Re: Bosque School Drainage Study Final Drainage Plan
Engineer's Stamp dated 12-4-12 (E12/D015)

Based upon the information provided in your submittal received 12-4-12, the above referenced study cannot be approved as the Drainage Master Plan (DMP) until the following comments are addressed:

SCHOOL DRAINAGE STUDY
COORS AND MONTANO

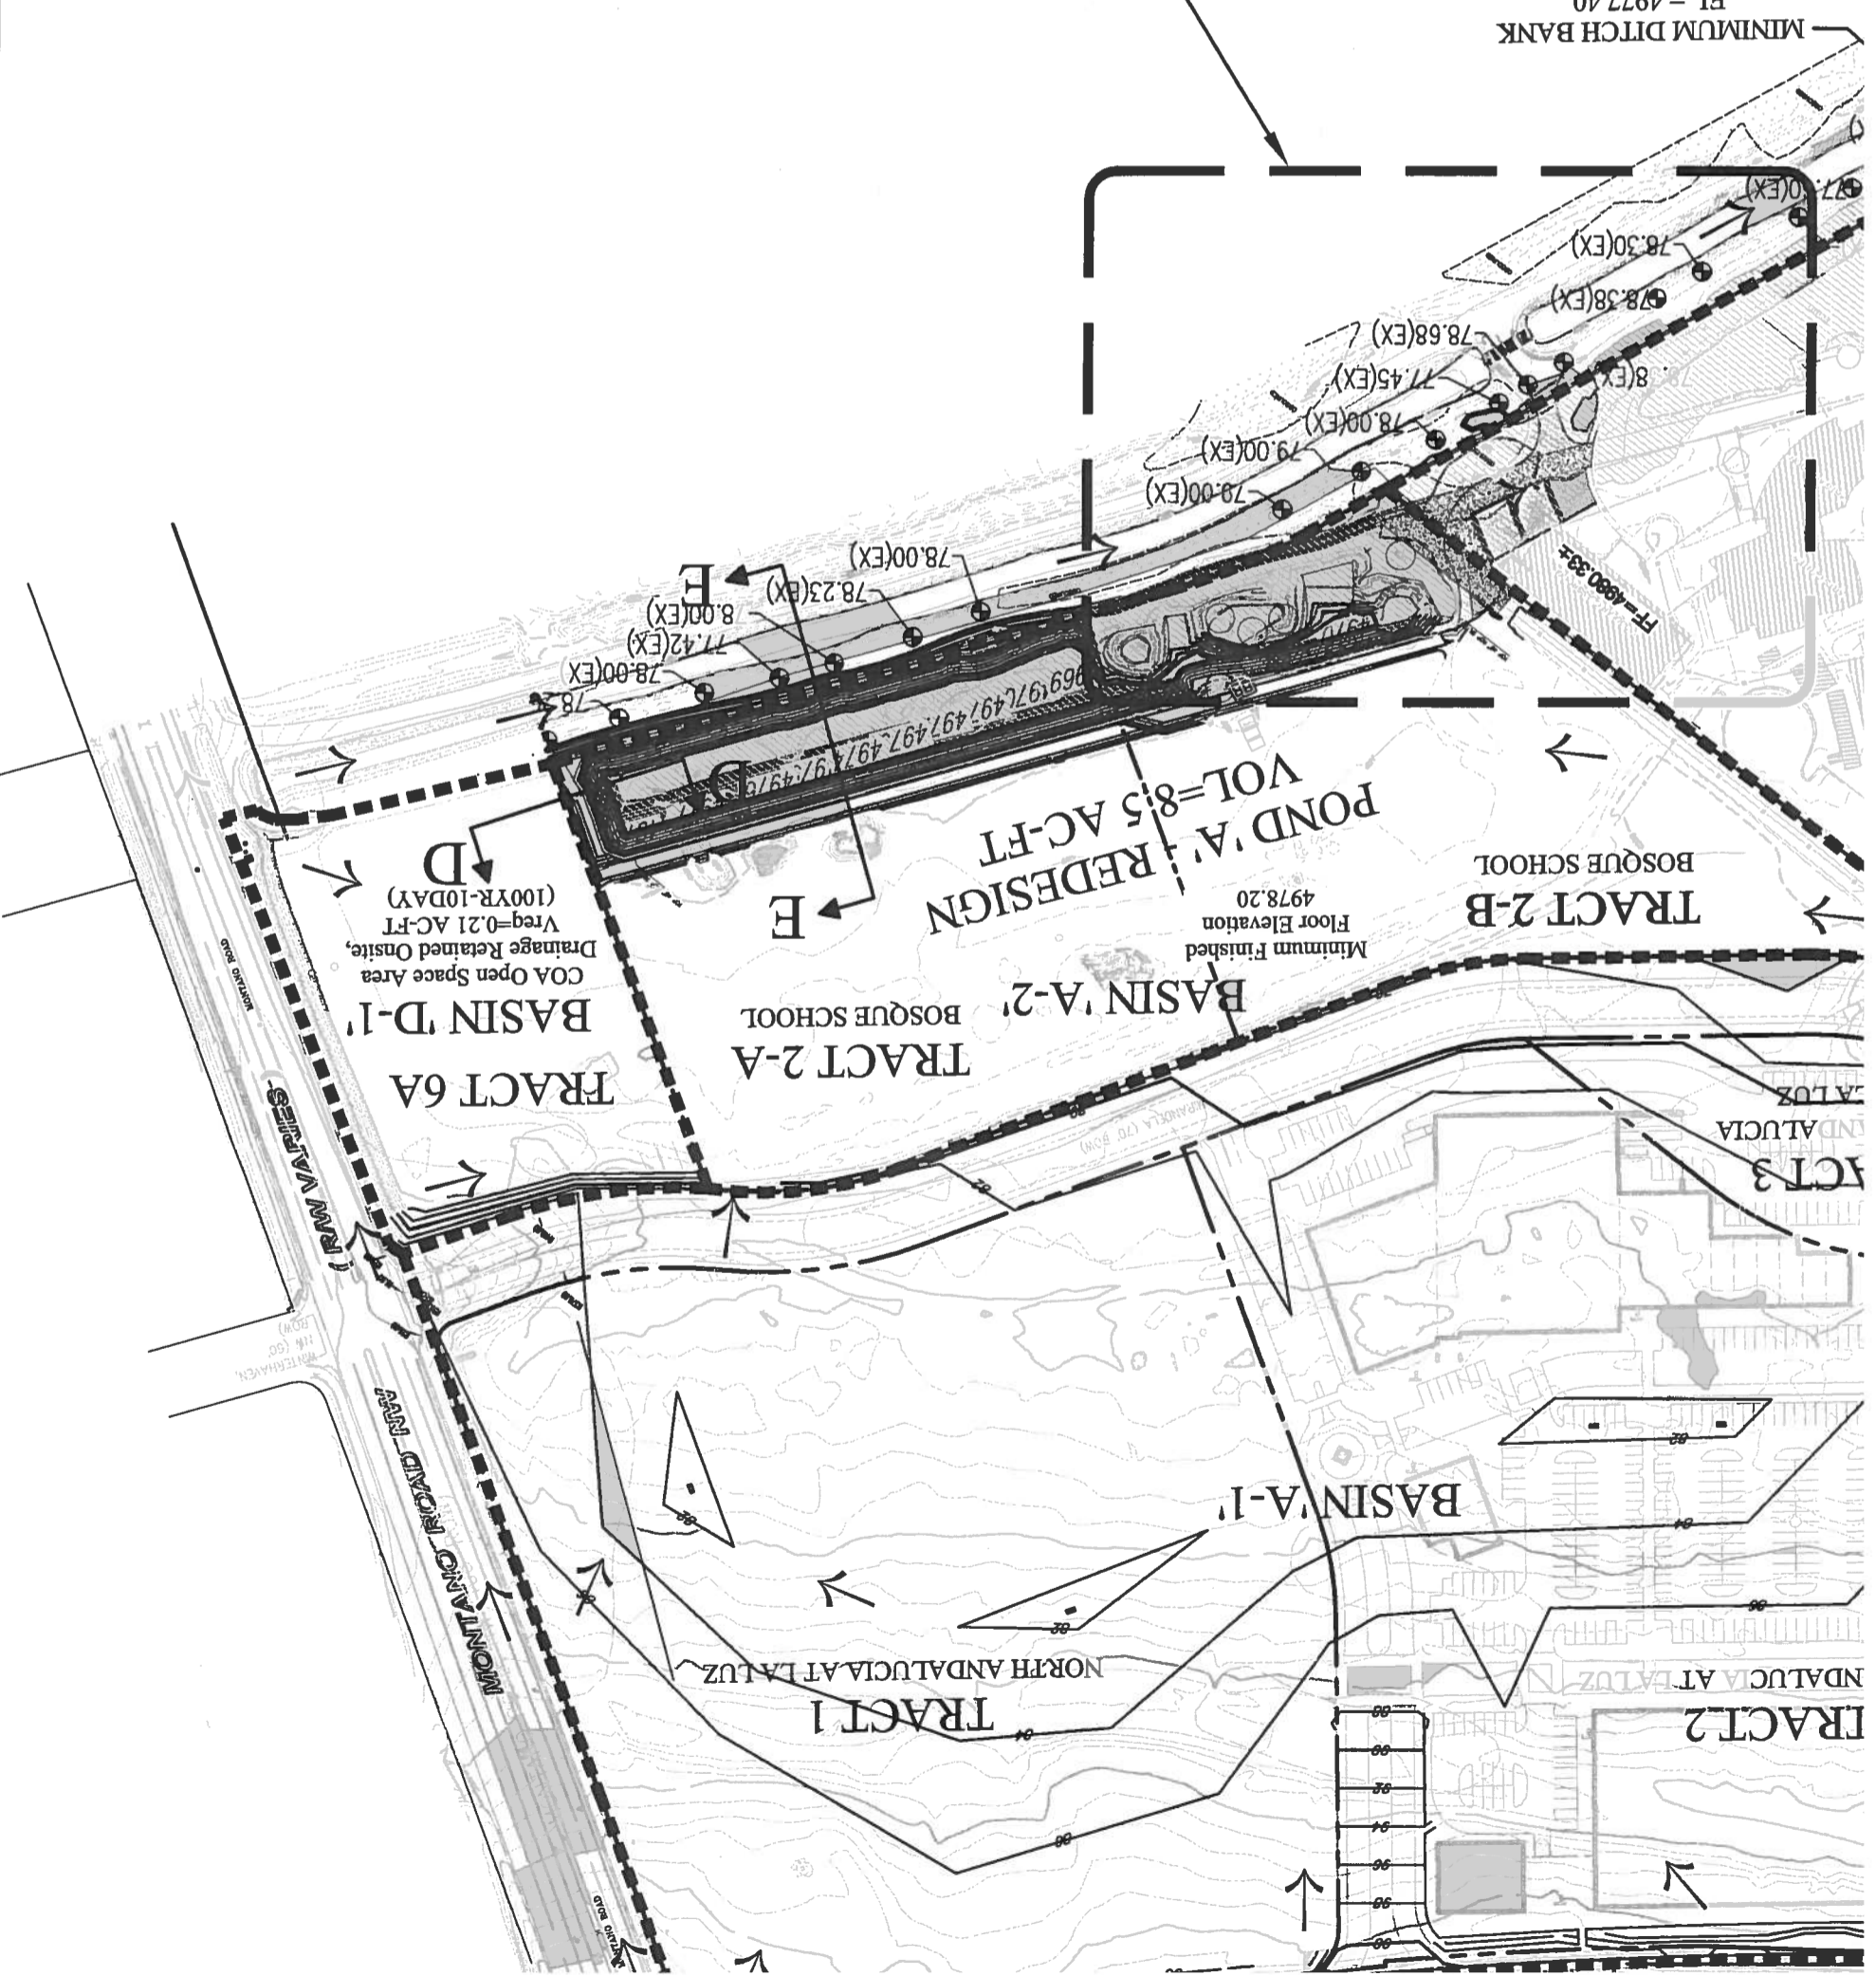
- The plan proposes the spillway underneath the modular classroom building, which is not acceptable. Provide a section halfway between sections B-B and C-C.
- Should the retaining wall proposed in Section B-B, wrap around the building beginning at the 78 contour on the north side to a 77 contour on the south side? Access to the east door of the building has to be maintained.
- What do the “hatched” bands symbolize in Detail D? A build note would be appropriate.
